Our Ref: Y/81/21/NMA

Non-material amendment following grant of Y/82/20/RES to replace the approved Capital Multi brick to New Cavendish and Thakeham brick to Weston Reds for plots 8-14 & 24-28.

Land to the south of Ford Lane east of North End Road Yapton BN18 0DS

Title:
MATERIALS PLAN

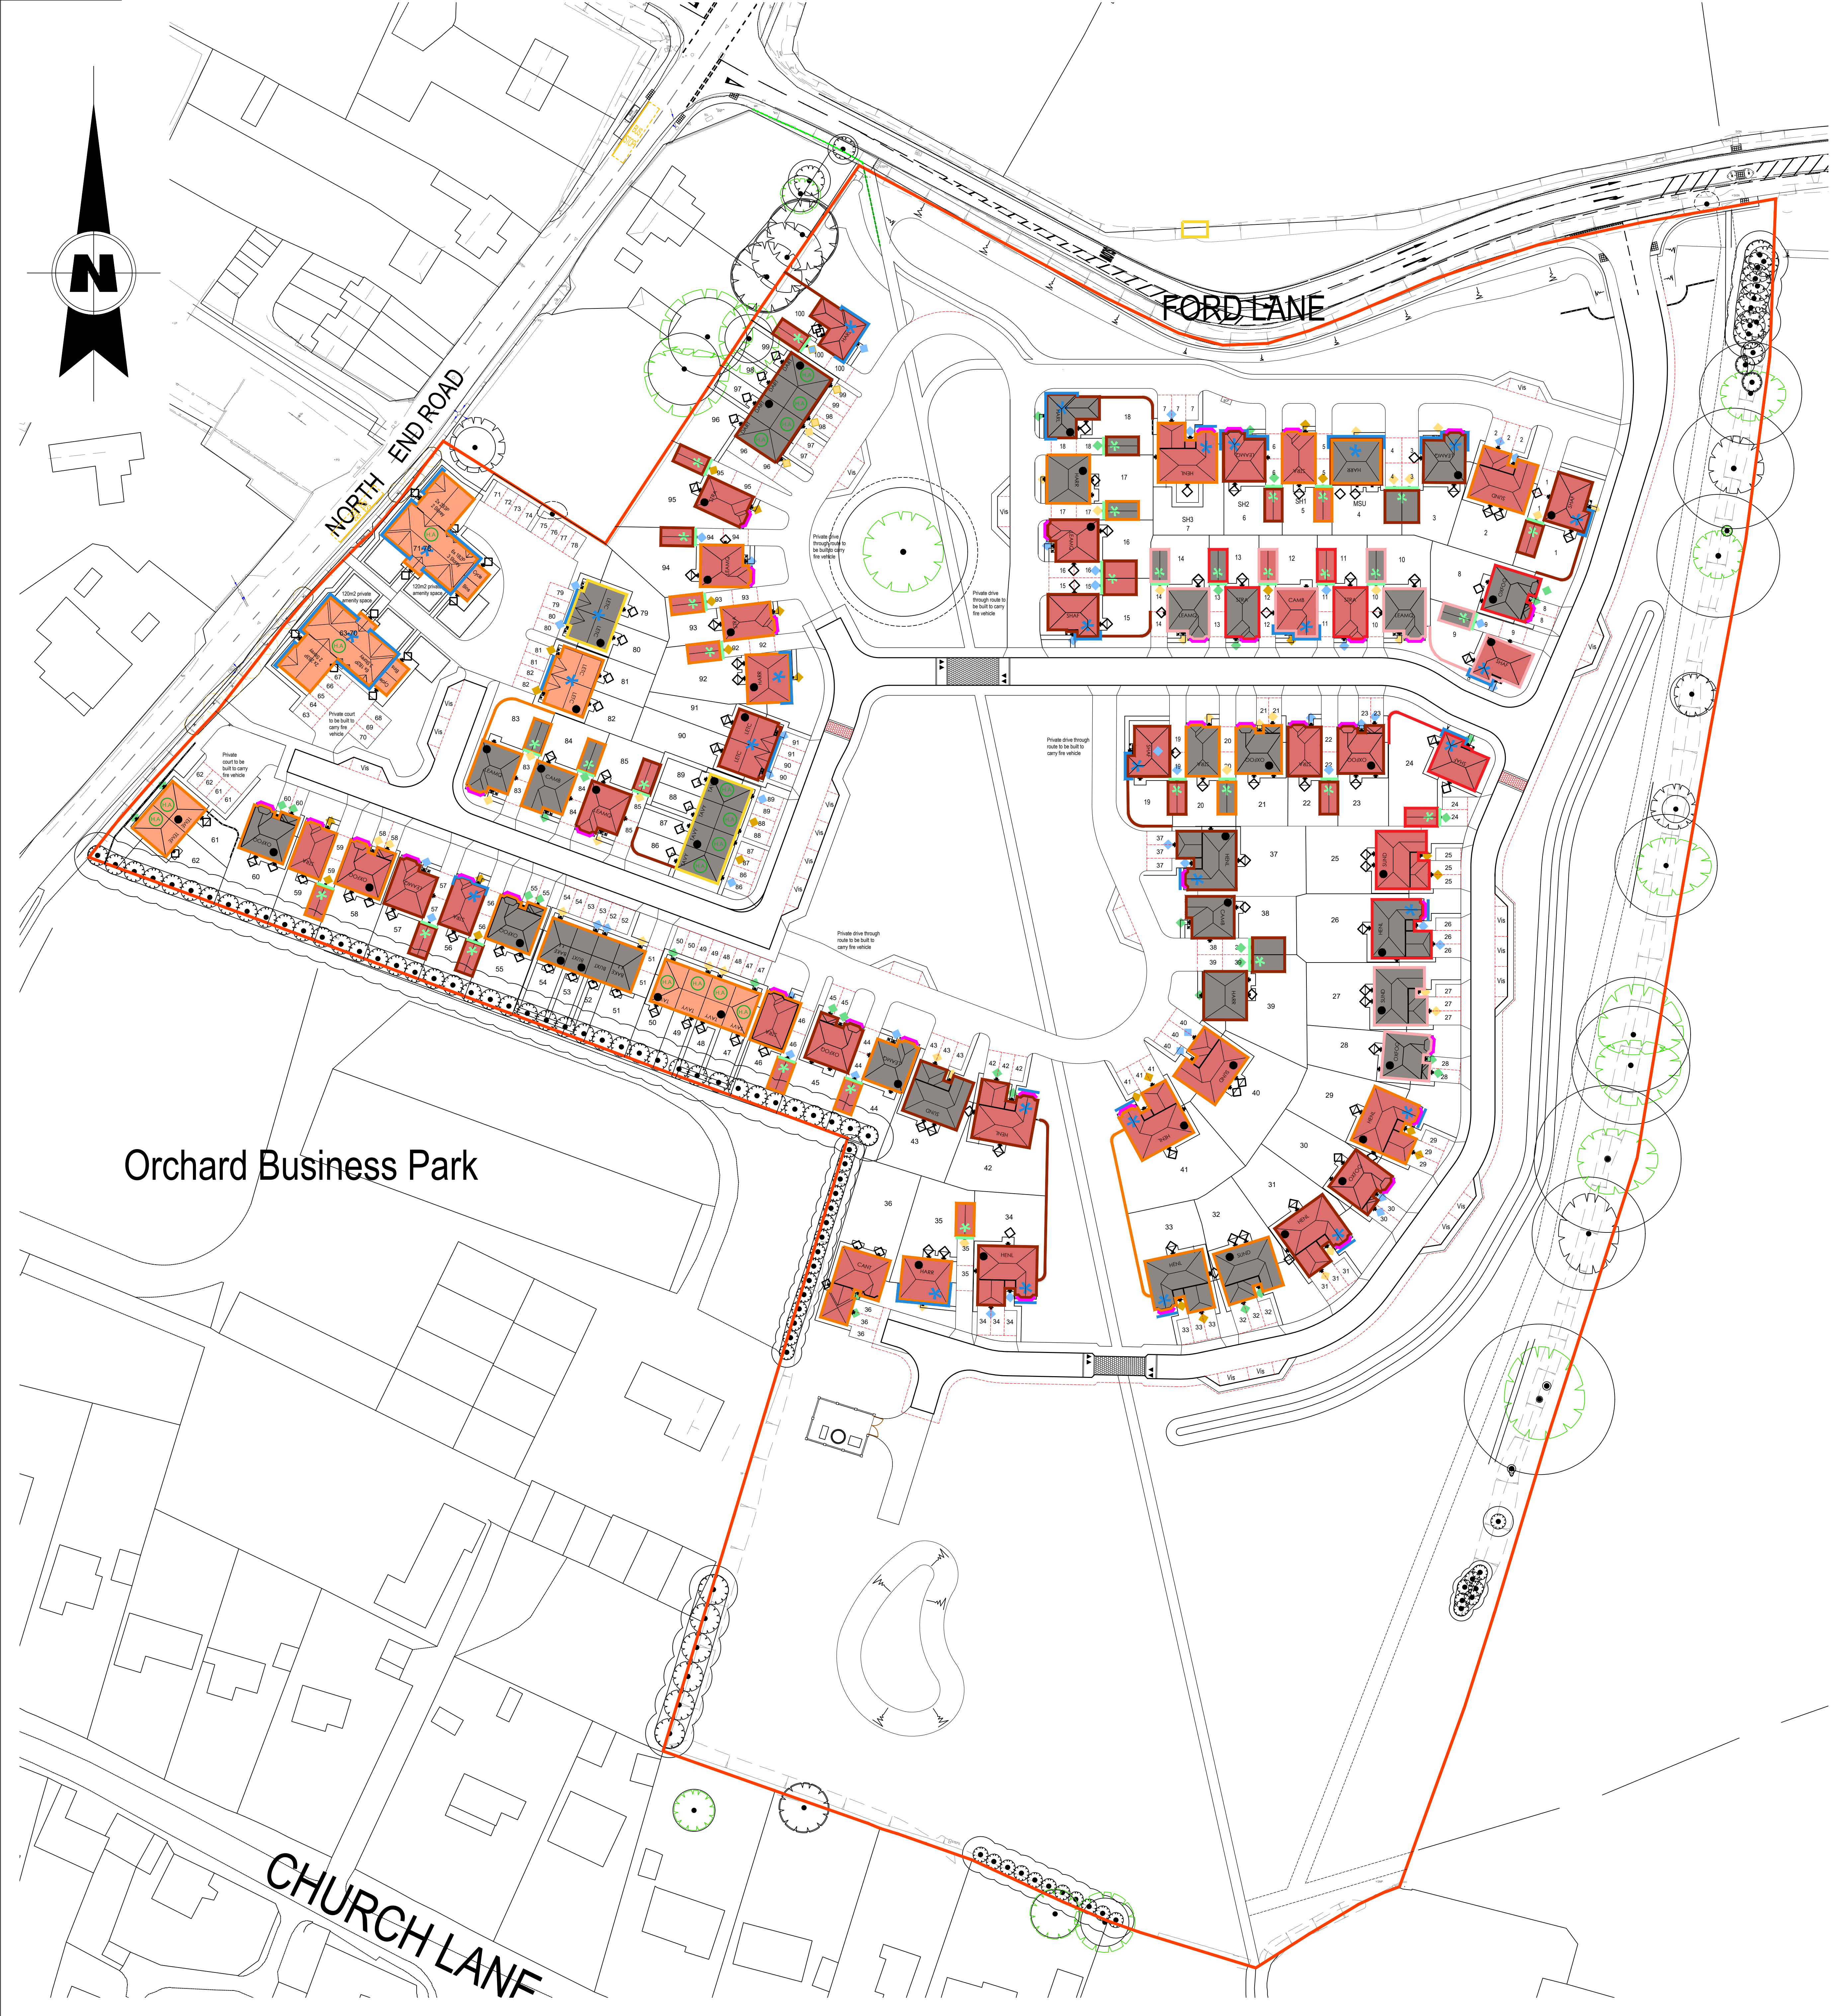
The reason that this proposal has been accepted as a Non-Material Amendment is because it is proposing to change the Capital Multi brick to New Cavendish brick and change the Thakeham Reds to Weston Reds on Plots 8-14 & 24-28, and it can therefore be considered under section 96A of the Town and Country Planning Act 1990.

Please note that Drawing No. A855-072 Rev. D - Materials Plan, now forms part of the approved planning documents and drawings for reserved matters approval Y/82/20/RES at Land South of Ford Lane and East of North End Road, Yapton in place of Drawing No. A855-

072 Rev. B - Materials Plan.
